Our Ref: AL/104/18/HH
Your Ref:

Town & Country Planning Act 1990 (as amended)
Town & country Planning (Development Management Procedure) (England) Order 2015
Application for Planning Permission for Works or Extension to a Dwelling

Development The installation of a 36 No. PV array on a barn in the garden that is to the rear of the main residence. This application affects the character & appearance of the Norton Lane, Norton Conservation Area.

Location Long Barn Norton Lane Norton Aldingbourne

BLOCK PLAN 1:500

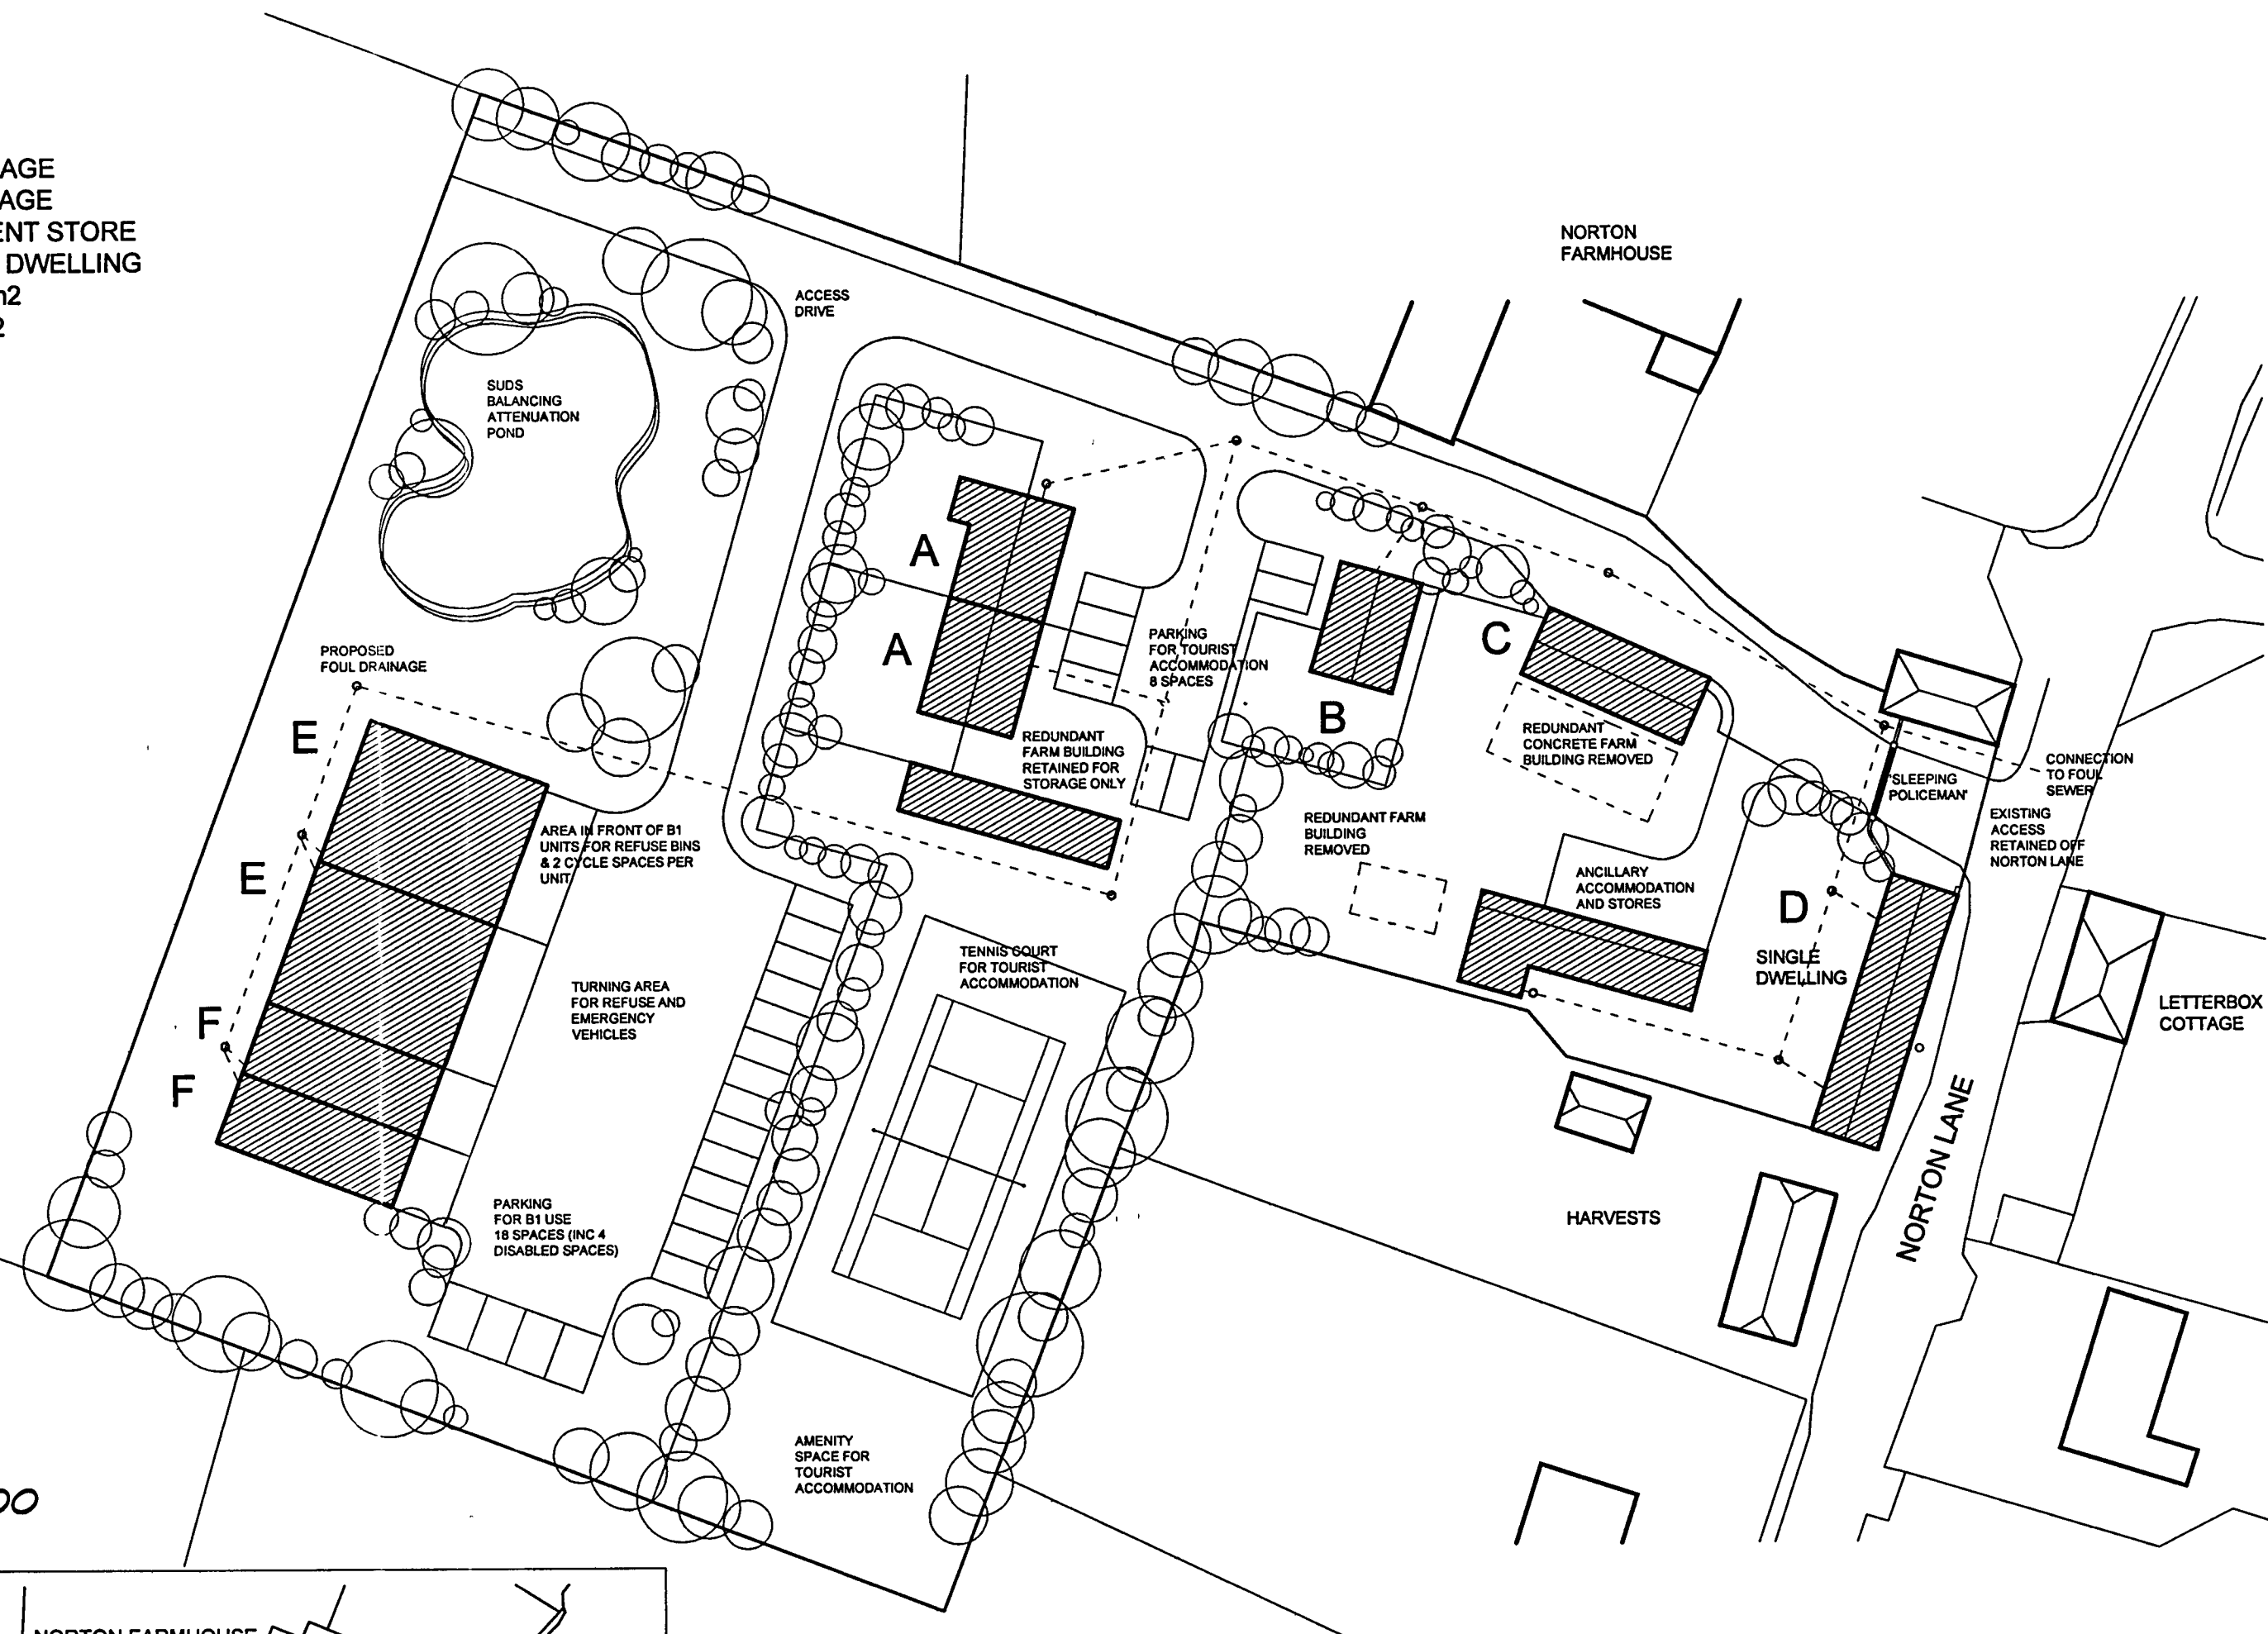
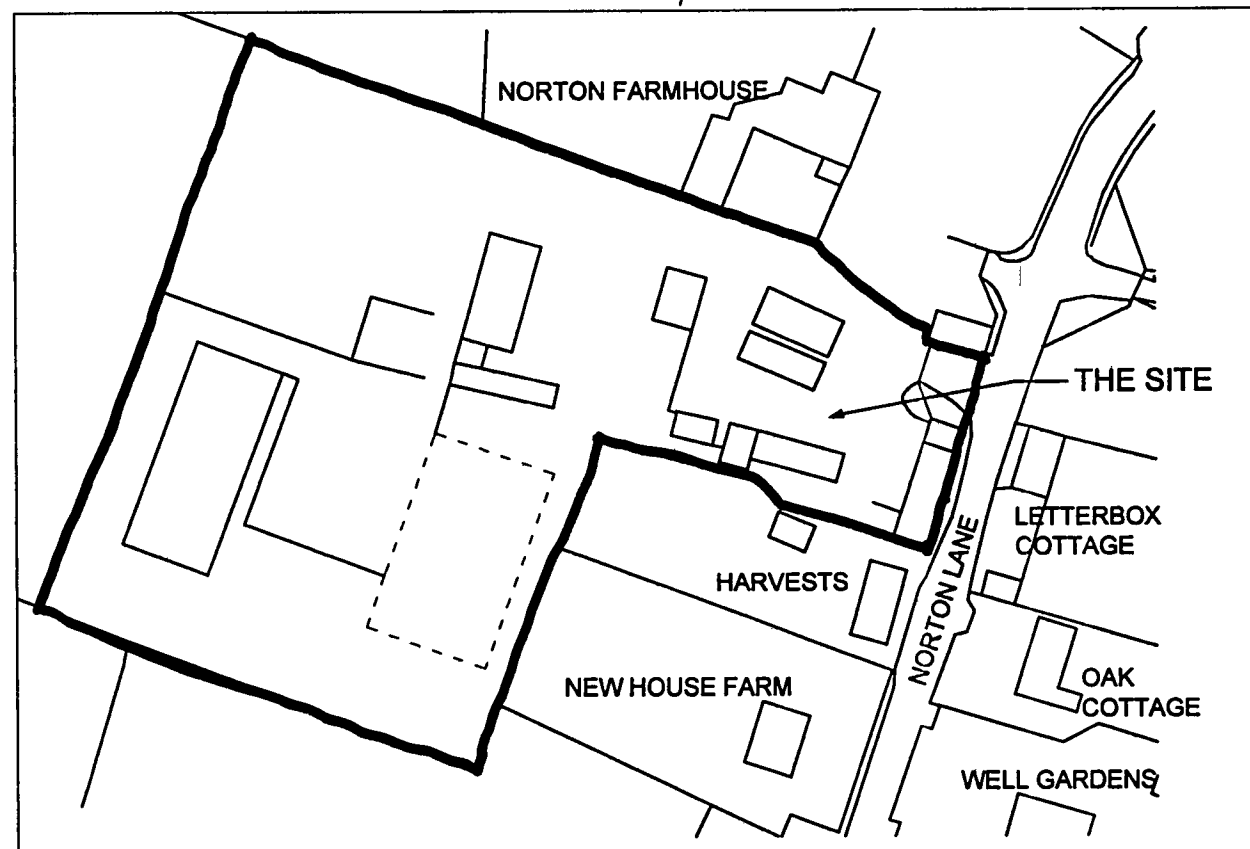
A plan was submitted with both a location and block plan. On this plan, please red edge the application site on the location plan and on the block plan, please clearly highlight the proposed works.

36 panels

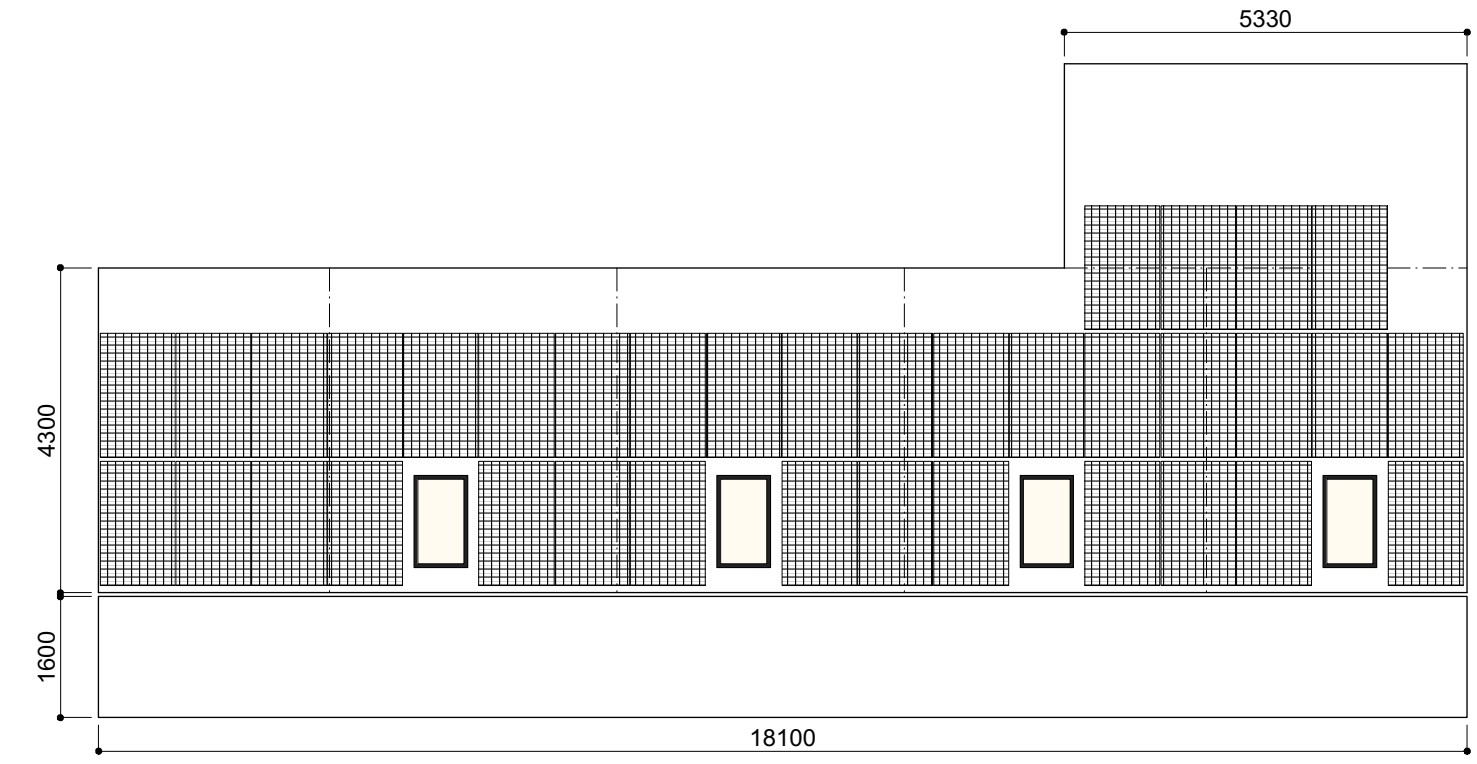
On the proposed roof plan and proposed south elevation, please show the 36 panels separately and not as one panel.
